Re: Status of Improvement Permit Application #06-5-14695R – Lt. 60 Forest Oaks

On May 15, 2006, an Environmental Health Specialist from the Harnett County Health Department attempted to evaluate your property for the purpose of issuing an Improvement Permit. This individual was unable to evaluate your property for one or more of the following reasons.

SURVEY FOR:
PROPOSED PLOT PLAN - LOT - 60
FOREST OAKS S/D, PHASES ONE & TWO

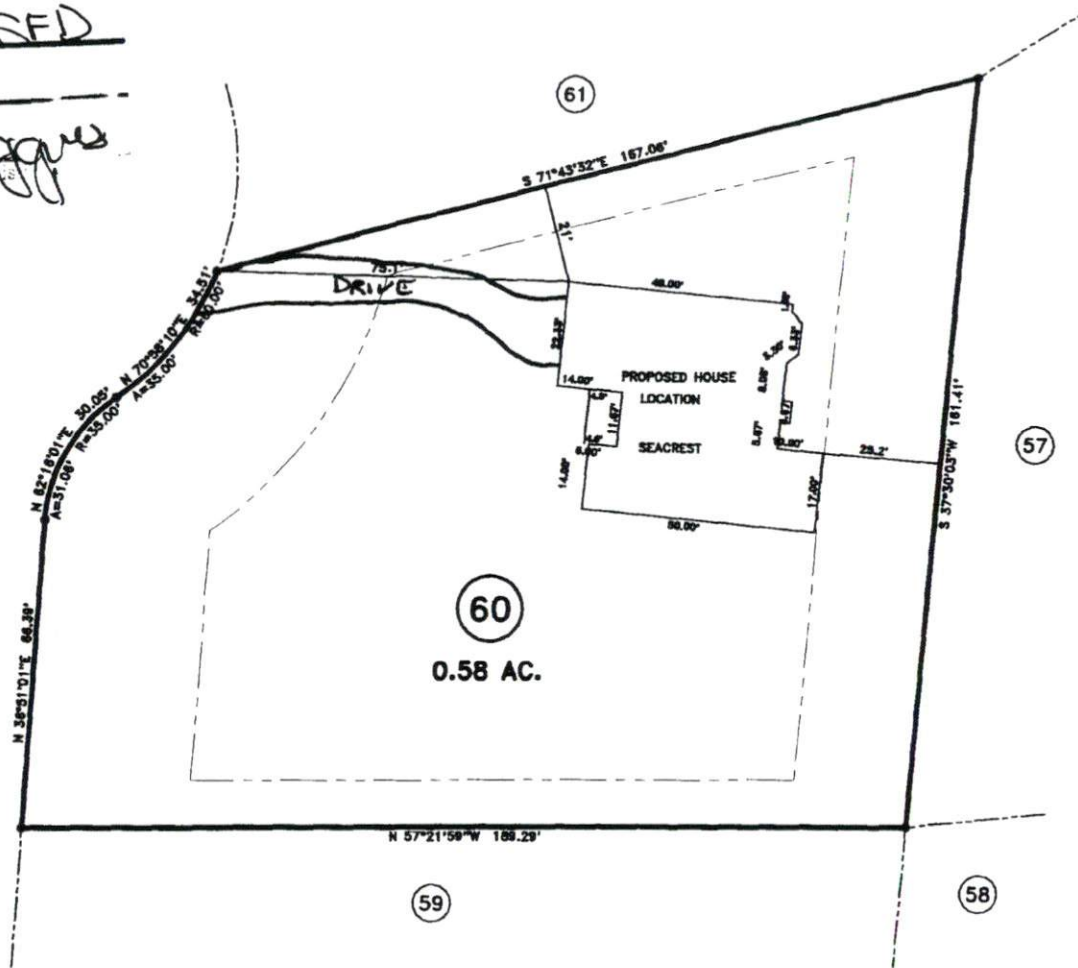
- 1. Property lines/corners not marked or labeled
- 2. House corners not marked or labeled
- 3. Directions not clear to property
- 4. Property needs brush or vegetation removed
- 5. Backhoe pits required
- 6. Other – **Please change Lot 60 to 3 bedrooms as requested previously.**
